Subject MP08\_0207 & MP10\_0219 - Avon and Beechworth Roads, Pymble

The NSW Department of Planning and Infrastructure (DP&I) is currently assessing a major project application for a residential development at Avon and Beechworth Roads, Pymble. Arup has prepared this document on behalf of the DP&I to provide an independent assessment of the key transport issues raised during the submissions period relating to the proposed application.

To	Helen Mulcahy	Date 29 May 2013
Copies	Ben Lusher	Reference number JDM/230501
From	Joshua Milston	File reference
Subject	MP08_0207 & MP10_0219 - Avon and Beechworth Roads, Pymble – Supplementary Transport Advice

**Figure 44** Possible alternate location for pedestrian refuge (Source: ARUP)

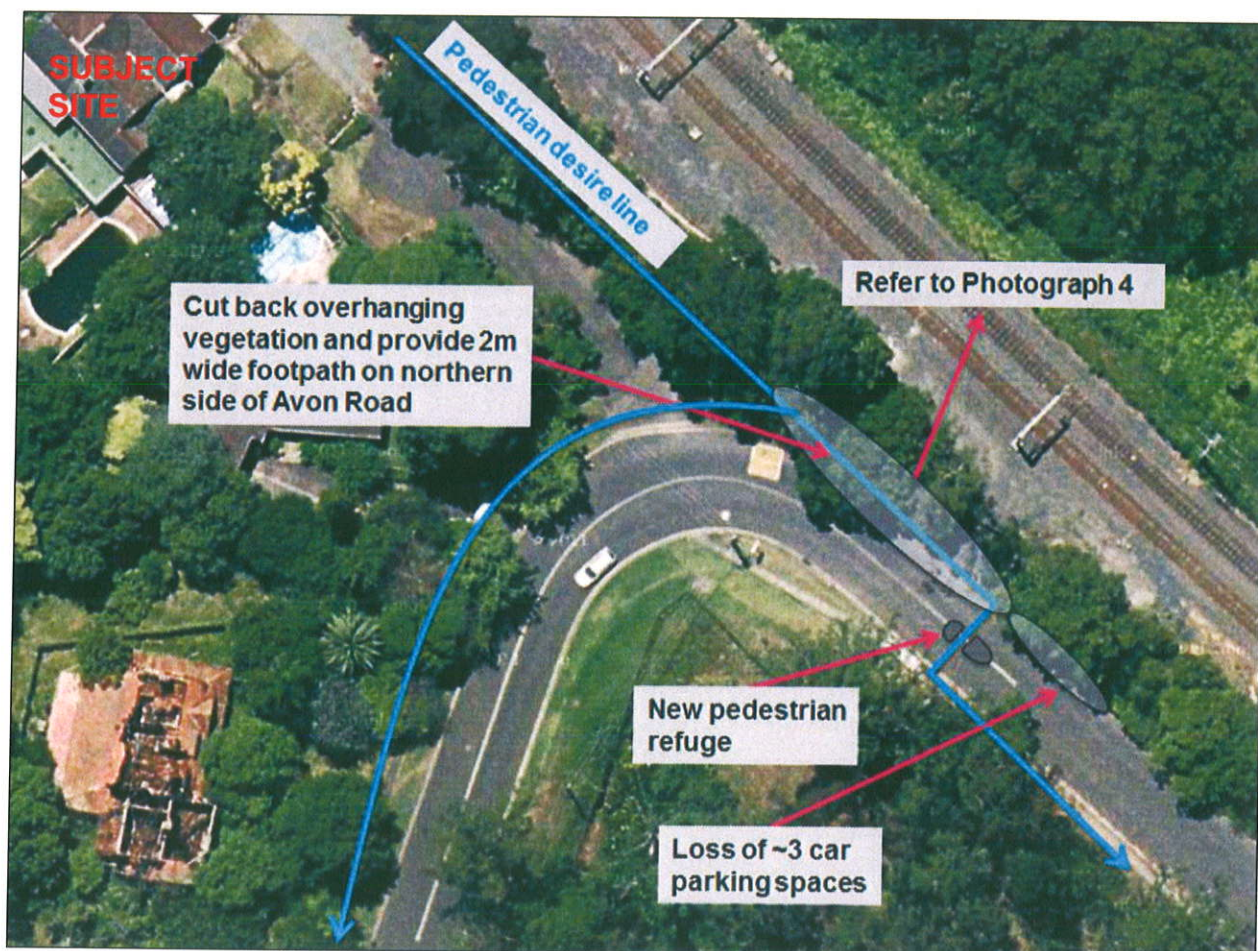
Given that the installation of a pedestrian refuge is unlikely to be possible at the bend in Avon Road, an alternative solution is to provide the refuge further south along Avon Road. This would require overhanging vegetation to be cut back on the northern side of Avon Road to provide a footpath up to the refuge, as well as the introduction of a no stopping zone which would impact three existing on-street car parking space. This option is summarised in Figure 3.

Option 3 (pedestrian refuge at site access) is considered the most optimal in terms of pedestrian connectivity, however if this is not possible due to the movement of coaches, the proponent should further consider the arrangement outlined in option 4 above.

Throughout the documentation, the proponent has failed to demonstrate that a pedestrian refuge either at the apex of the bend on Avon Road, or further south as proposed by Arup, would not be feasible. Either of these options would provide a much improved solution for pedestrian connectivity. Considering that the traffic report asserts that the site is well connected to local public transport – much of this benefit will be lost if appropriate pedestrian links are not provided.
